**Re: City East Zone Substation Project - Stage 2A(ii) Revised
Application No. 11_0092**

Reference is made to the City East Zone Substation Project being Major Project Application Number 11_0092 prepared on behalf of Ausgrid which is currently on public exhibition (the proposed City East Zone Substation (CEZS) and the Integrated Commercial Tower project is herein referred to as the "Project").

We are the registered proprietor of Lot1 DP59871 and Lot 2 DP217112 being the commercial office property located at 44 - 48 Hunter Street, Sydney, which shares a common wall, boundary and driveway with the Project.

Figure 6-1 Predicted Construction Noise from Excavation

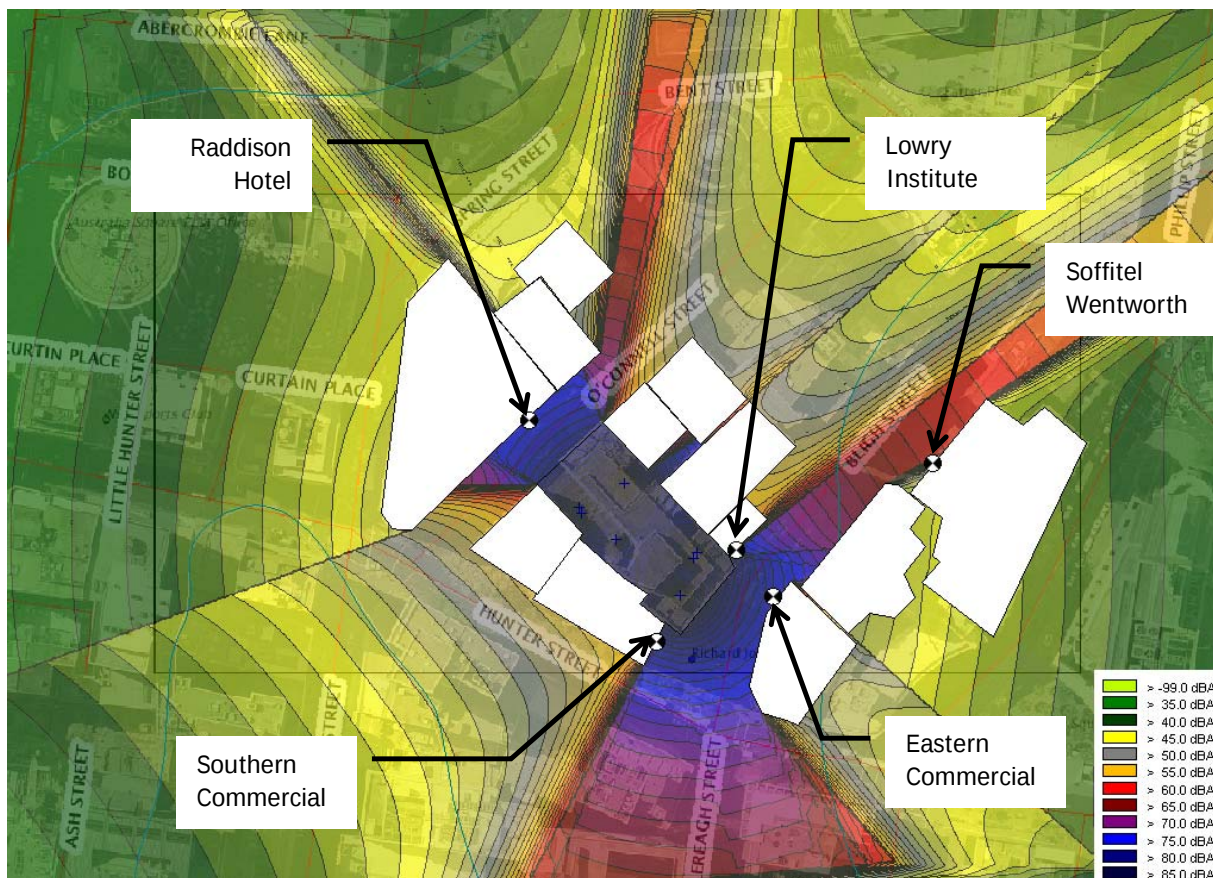
- (iv) With regards to Section 6 of the Wilkinson Murray report, clarification is requested in respect of the construction duration. Table 2-1 (page 4) provides an estimated duration, however there is no clear correlation with the different construction scenarios defined in Section 6 and thus, it is not clear for how long each construction scenarios will occur, which is a crucial and critical issue considering that it will define for how long the noise and vibration exceedances may happen. We also need clarification as to what level (height in metres from the ground) the color map in the Construction Noise Table in 6.1 was produced.

- (v) We need clarification as to why the noise and vibration for the proposed underground tunnel has not been assessed upon our property, given that Figure 6.2 of the report clearly shows noise and vibration exceedances in the approximate area of our property. We also need clarification as to what level (height in metres from the ground) the color map in the Construction Noise Table in 6.1 was produced inclusive for the tunnelling noise.
